SITE PLAN DRAWING

PROJECT NAME: 5930 Pacific Ct.
SUBMITTAL DATE: 5/10/2018
SUBMITTED BY: Amartin
SUBMITTAL REVIEWED BY: _____

PLOT PLAN DRAWING

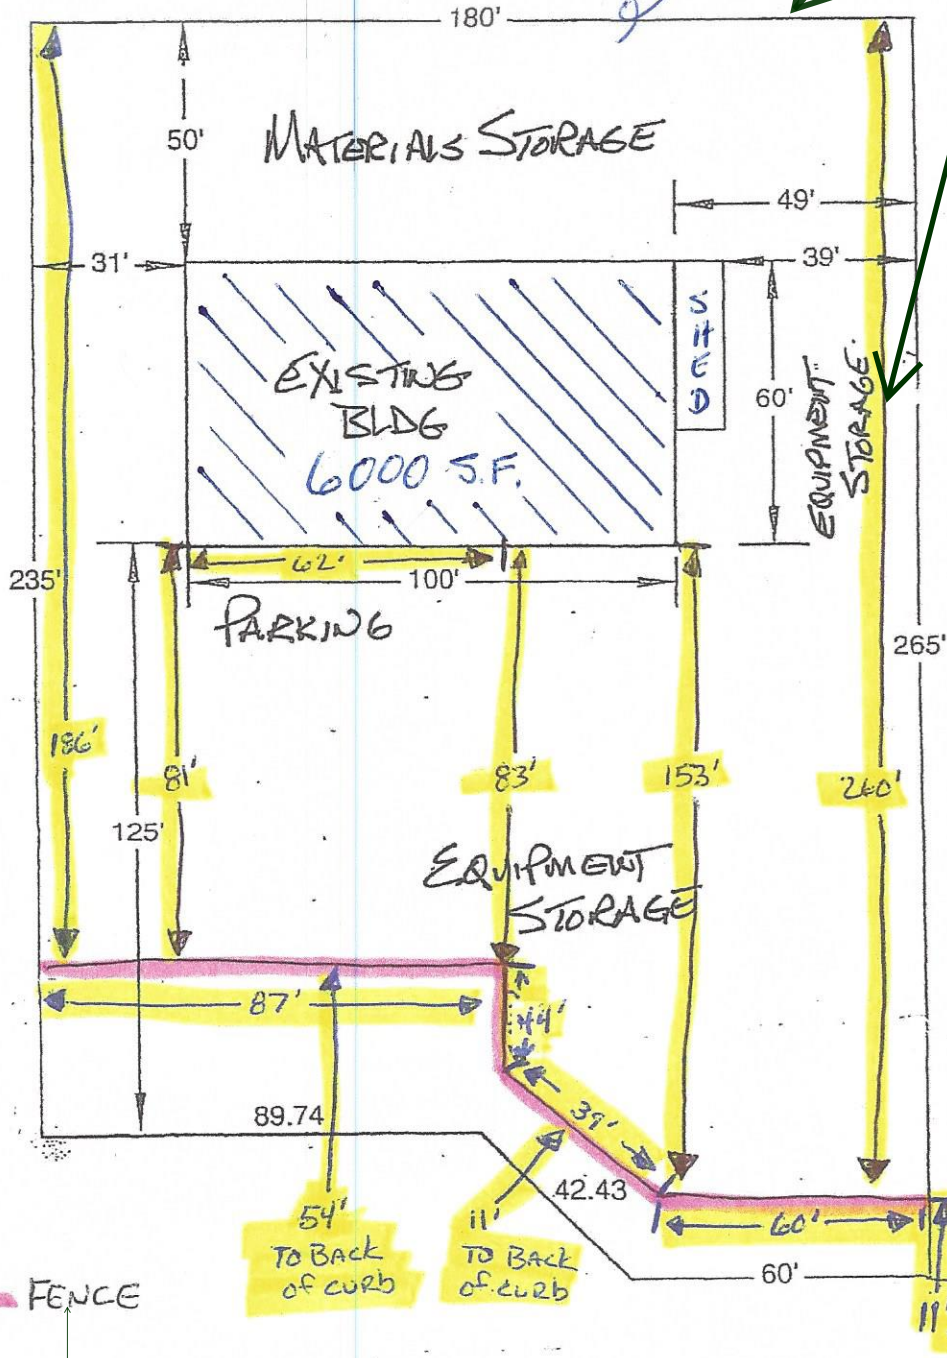
Where is the access? How tall is the pink fence? We cannot accept the ILC, take the information from it and include it in your site plan. Address Engineering Comments in EDARP.
